Figure 1 Property Map

Markup Summary

IMPROVEMENT LOCATION CERTIFICATE  
 (If is not a property survey)  
**Landmark Land Surveyors Ltd**  
 (A division of C. A. Jacobsen Engineering Ltd.)

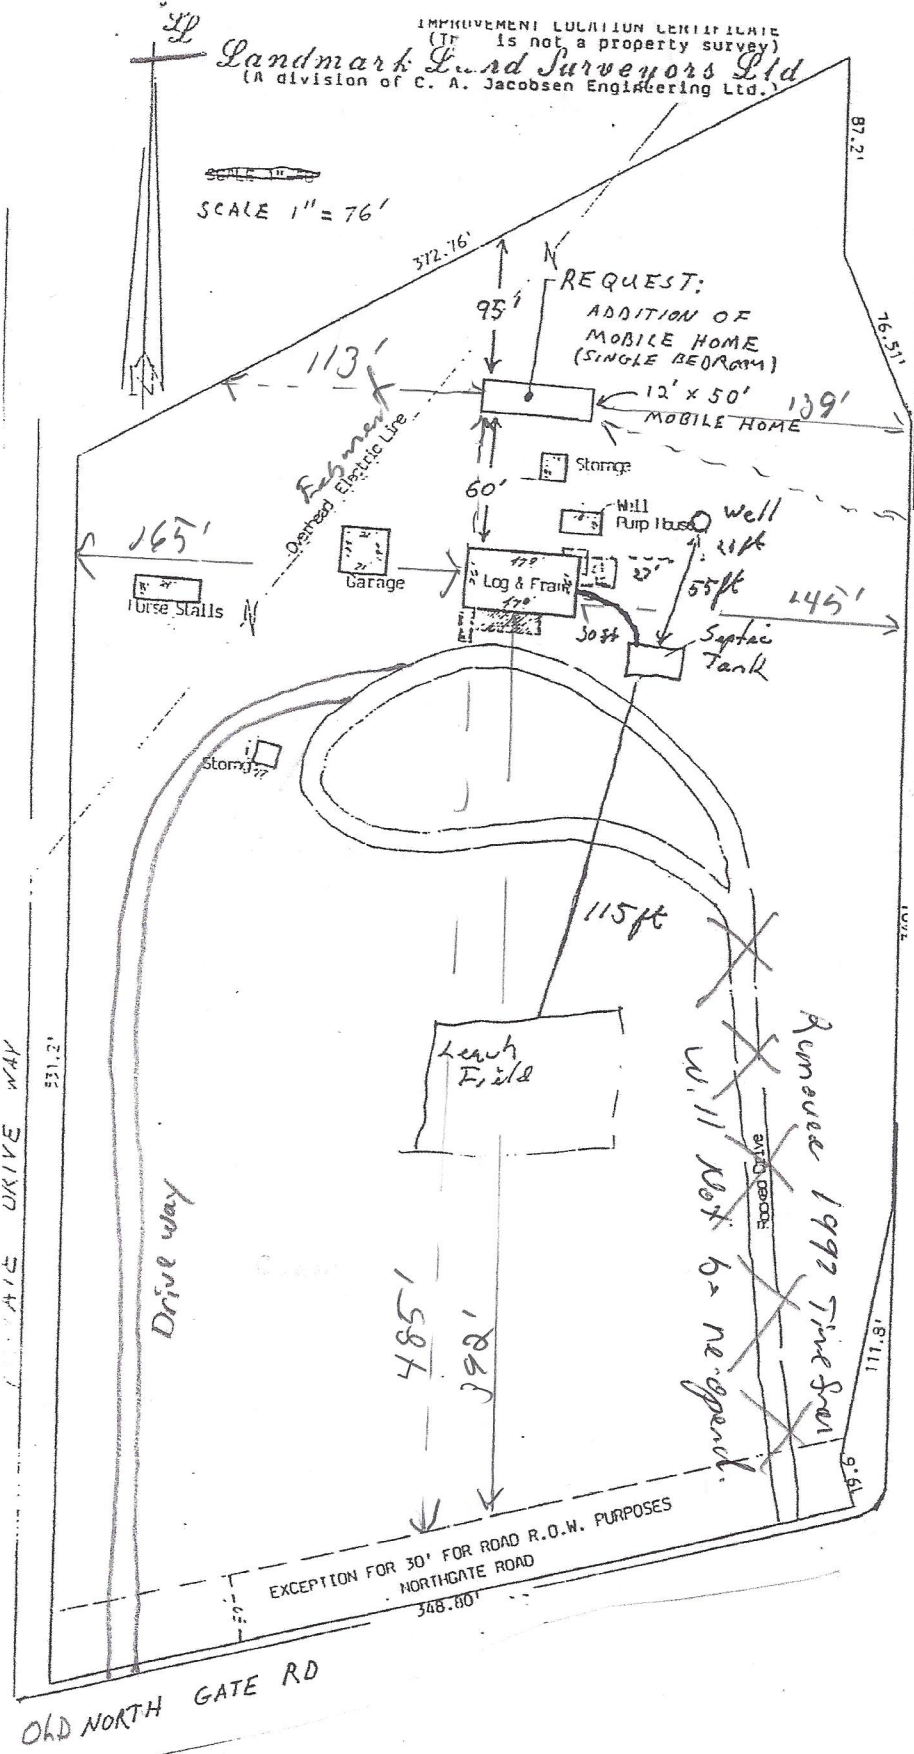
Show easement

Show Setbacks from all property lines
